National Grid Electricity Transmission – Sea Link – EN020026

Comments on Applicant's Change Request

Benhall Bridge – Traffic Diversion Route

# 2.7.1 Access, Rights of Way and Public Rights of Navigation Plans - Suffolk

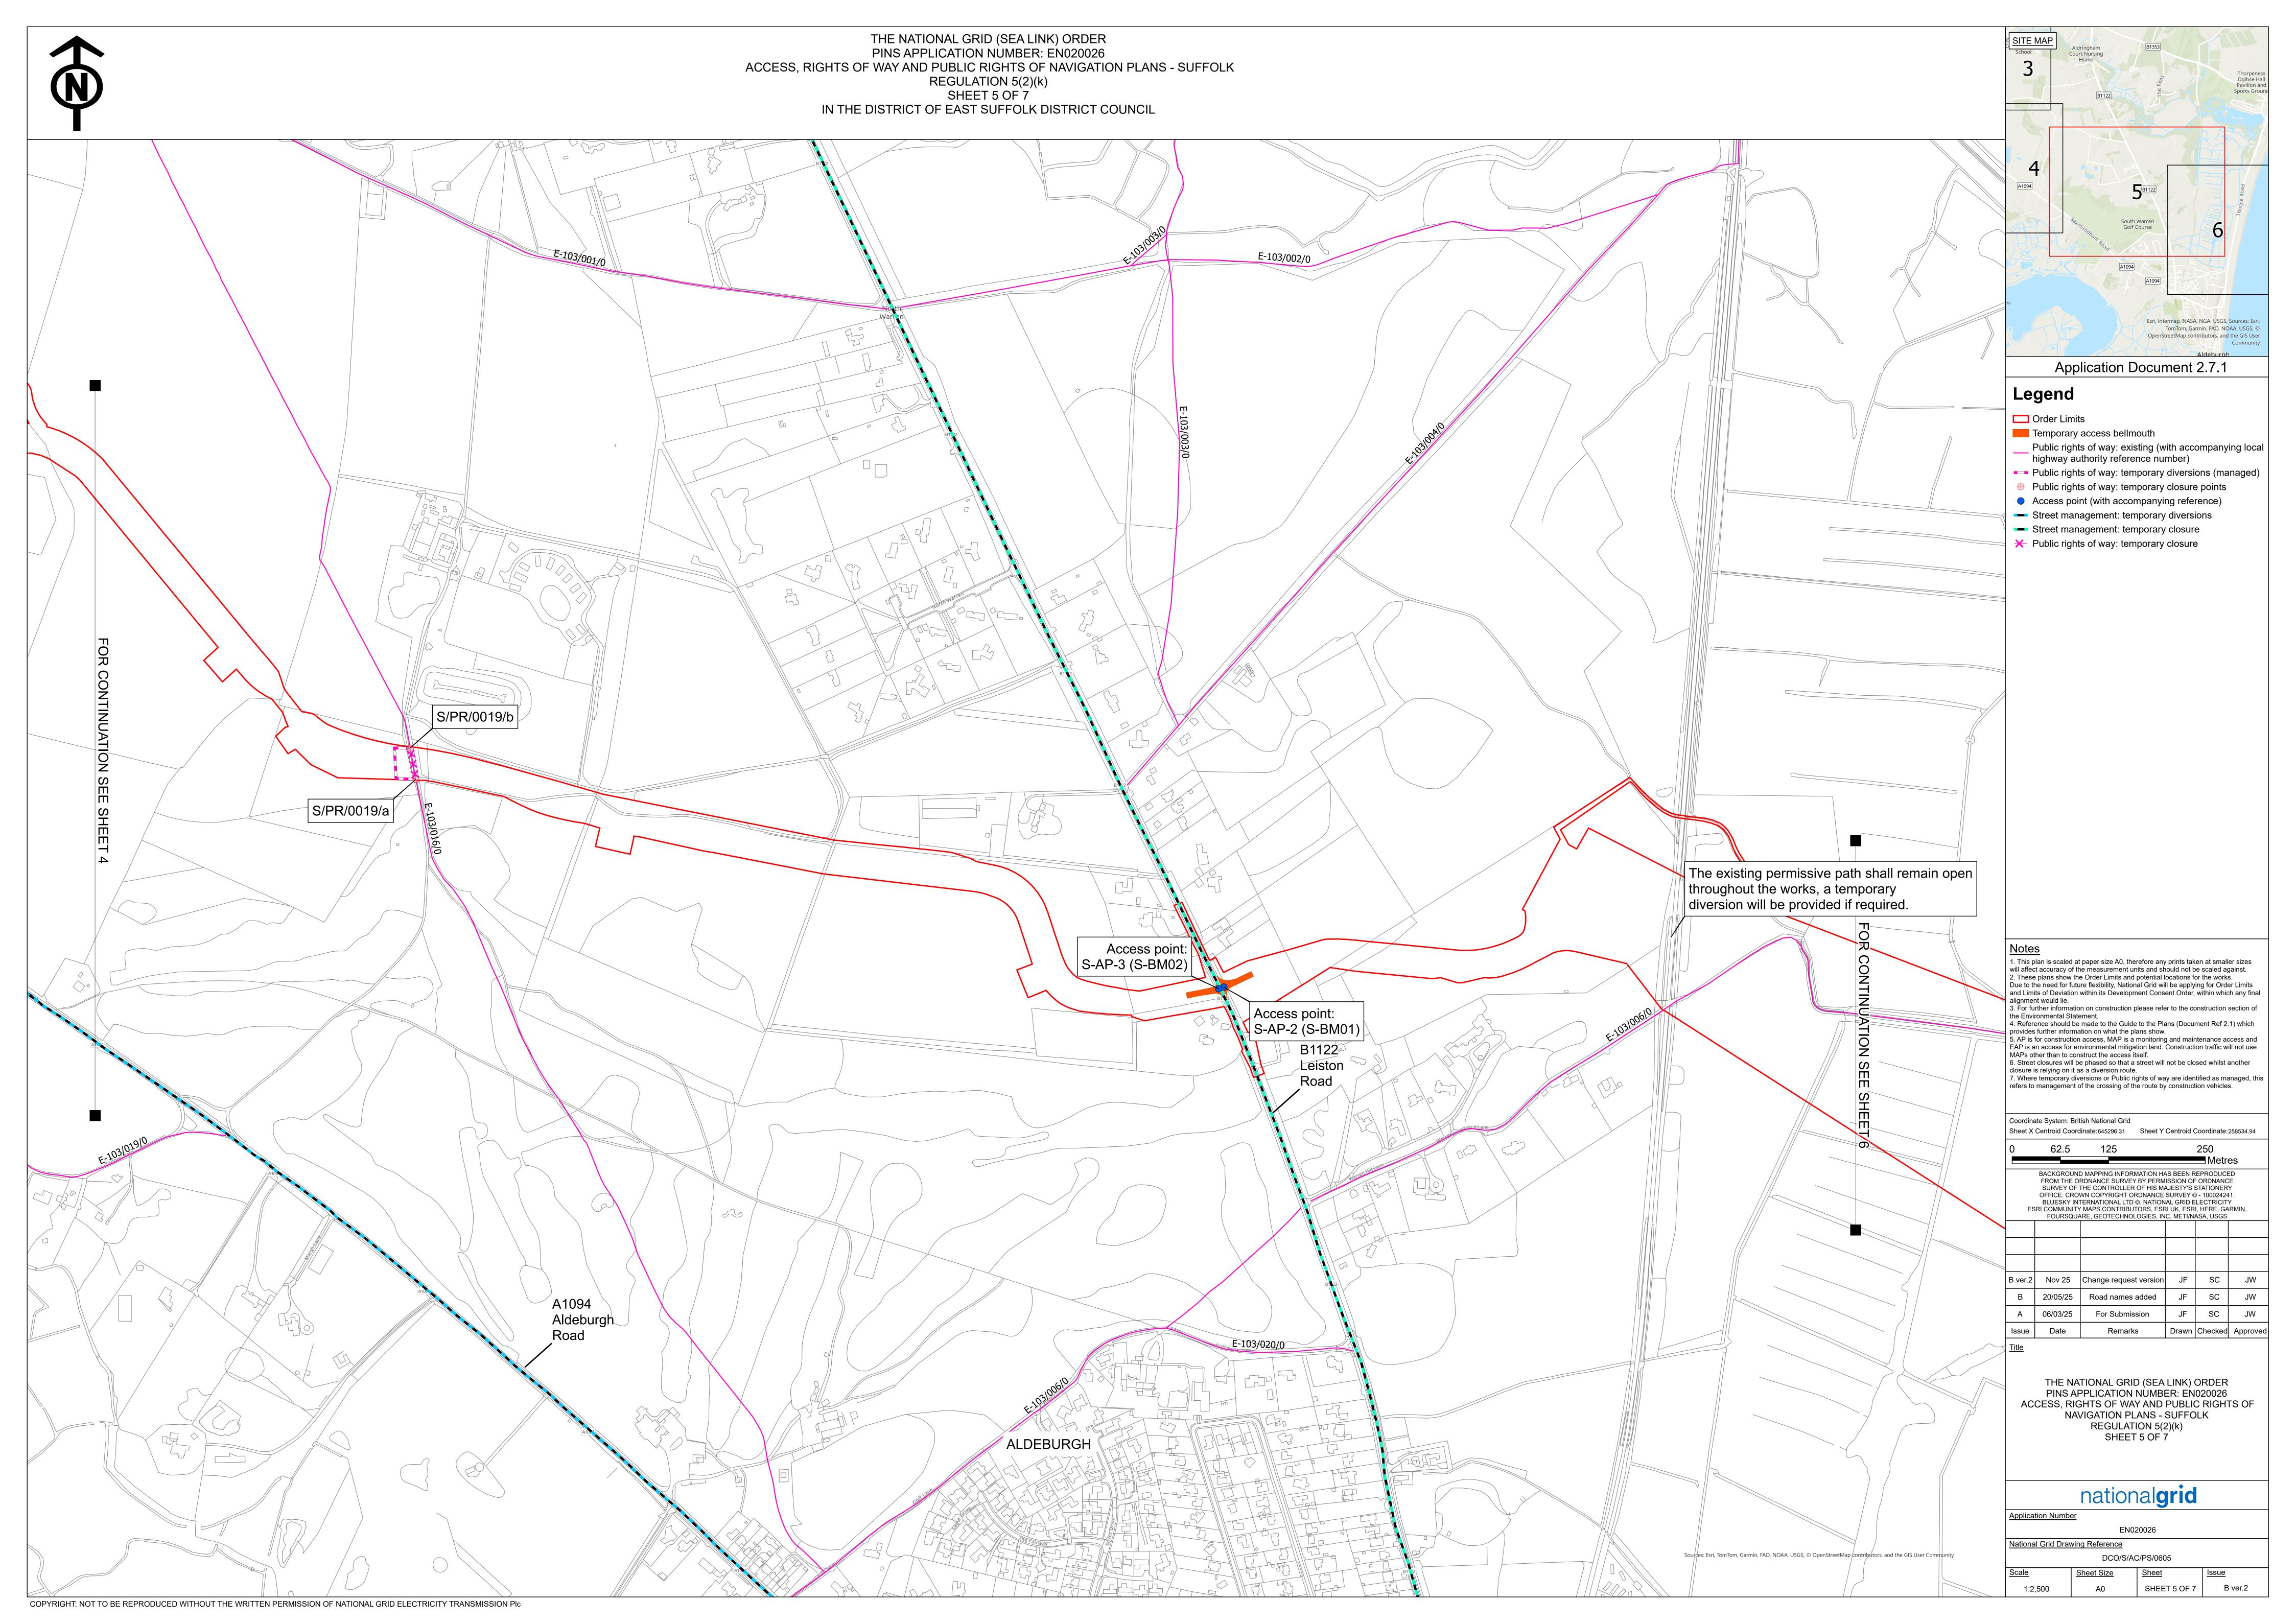
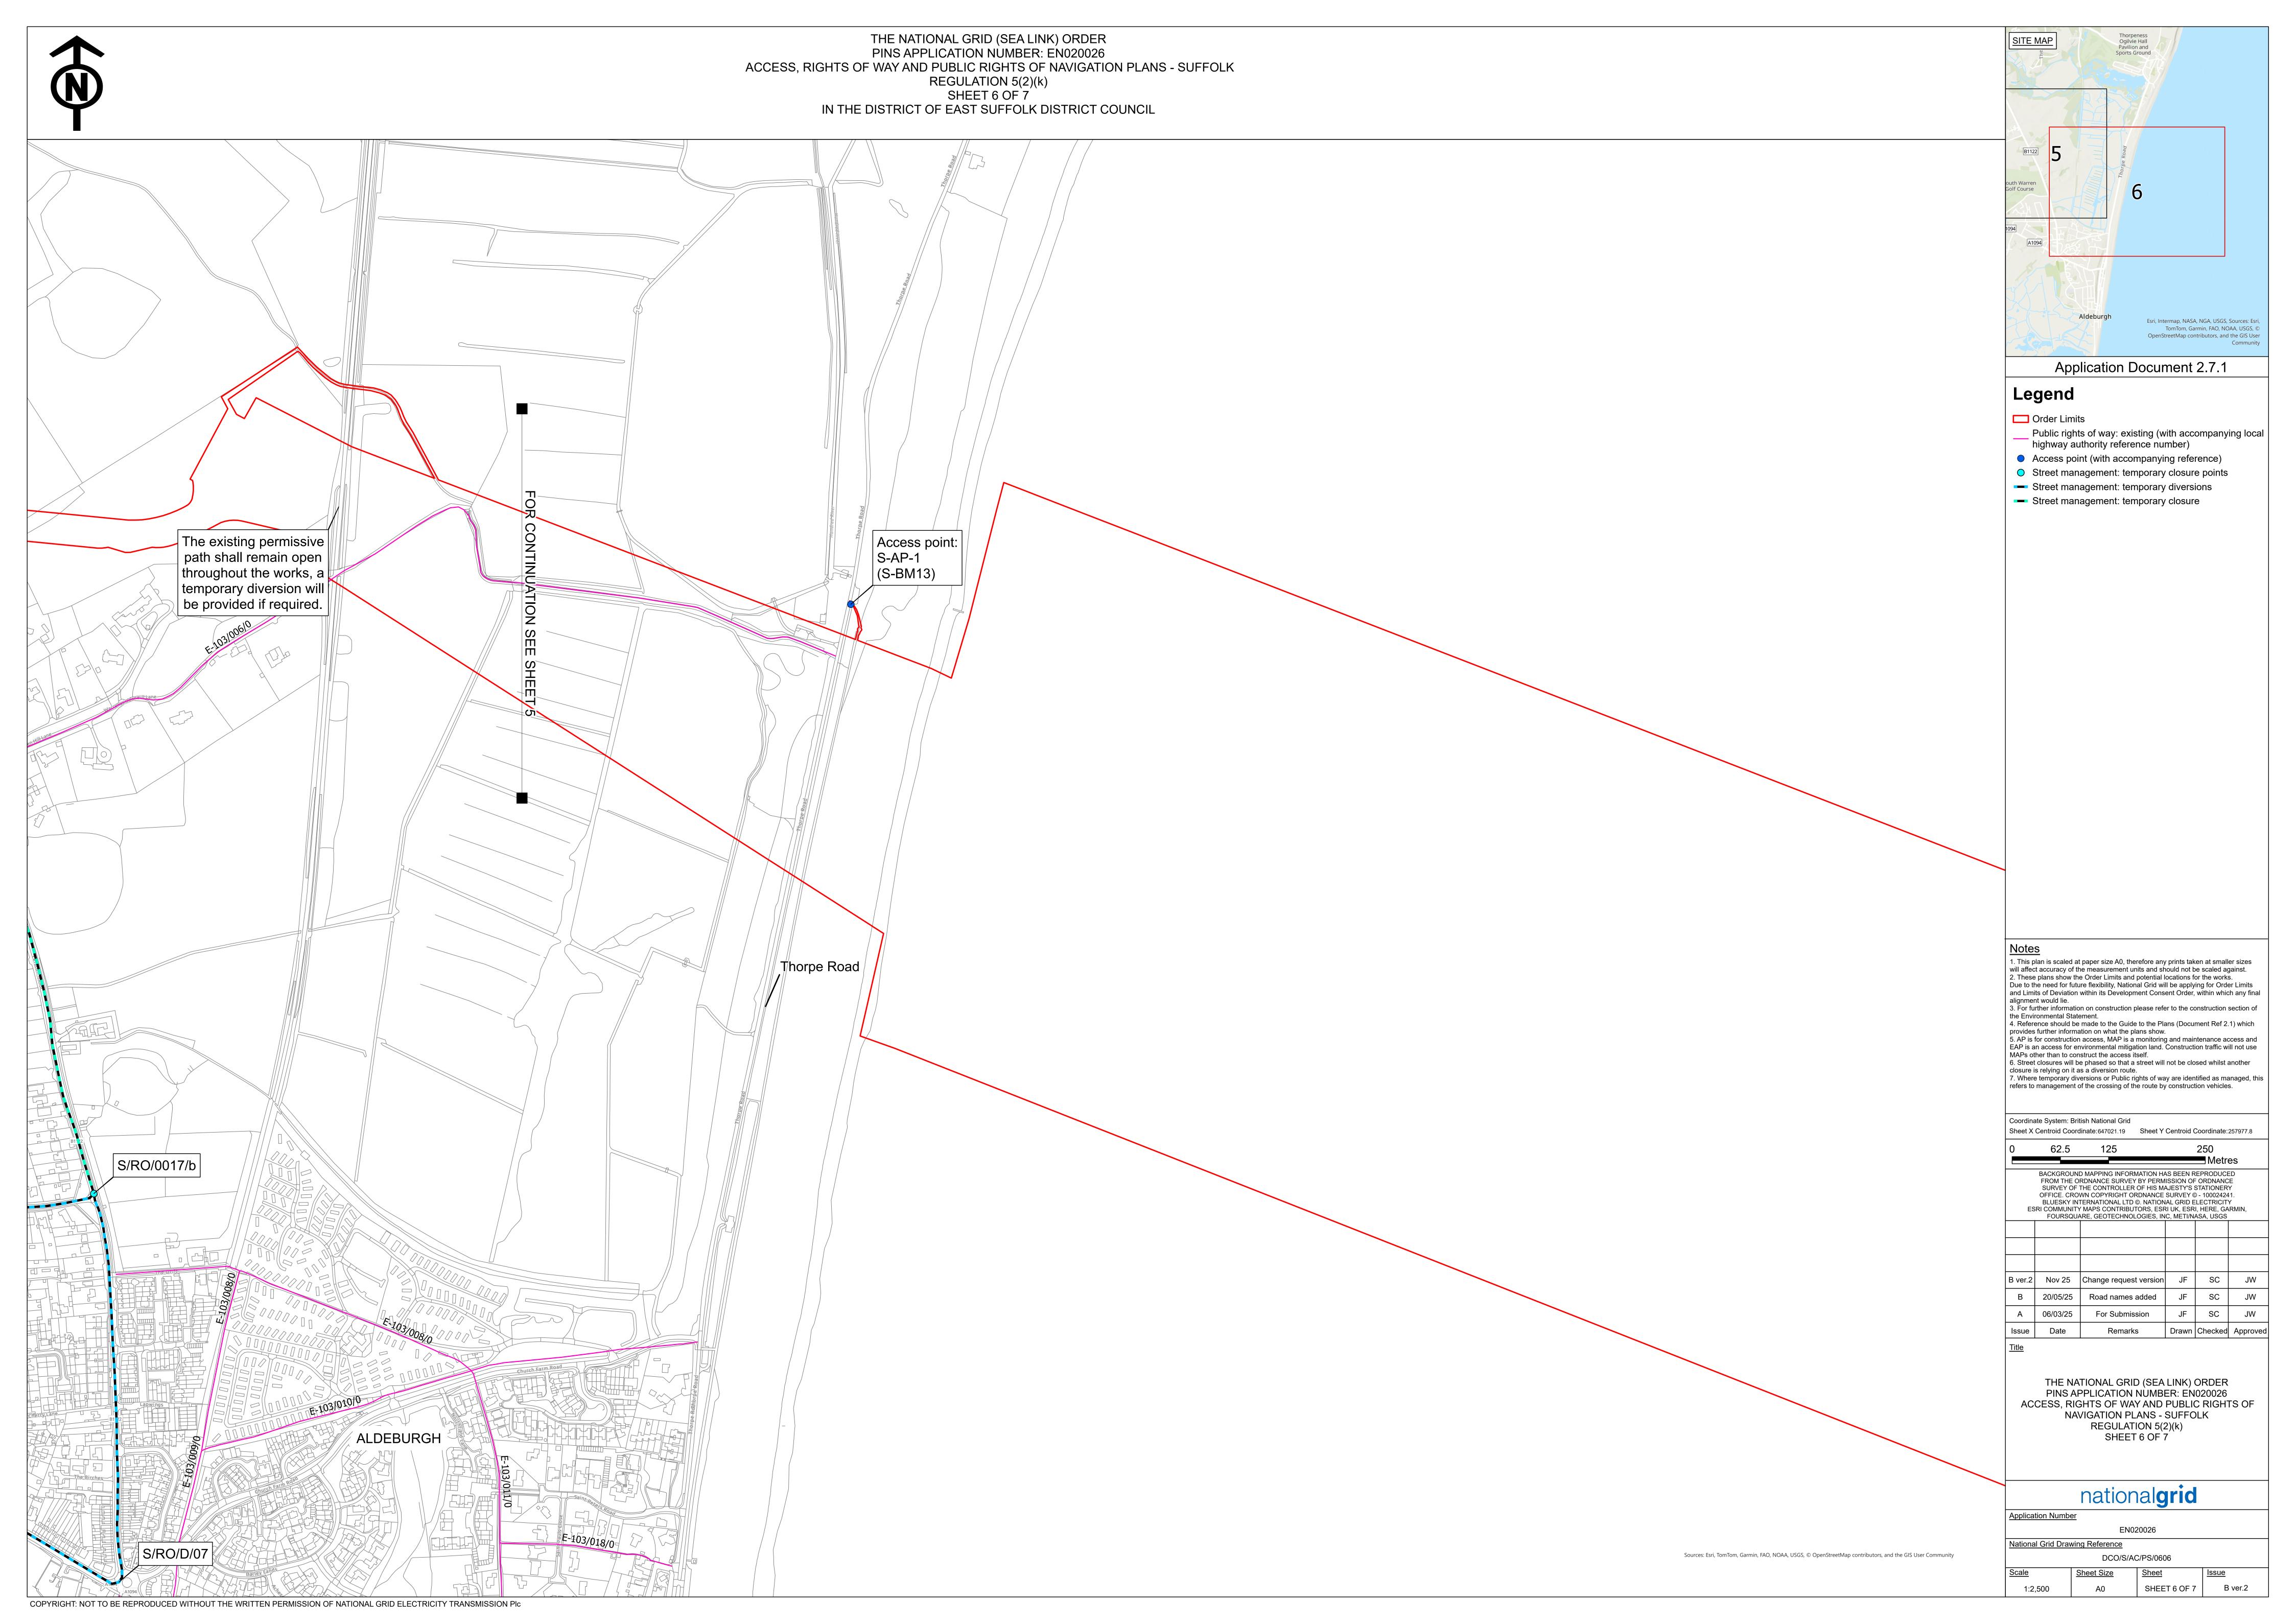
Ensuring HGVs do not follow the diversion route as illustrated on Document 2.7: Access, Rights of Way and Public Rights of Navigation Plans, Version: B Version 2 Change Request, November 2025 but instead use the designated HGV routes identified by Suffolk County Council Highways.
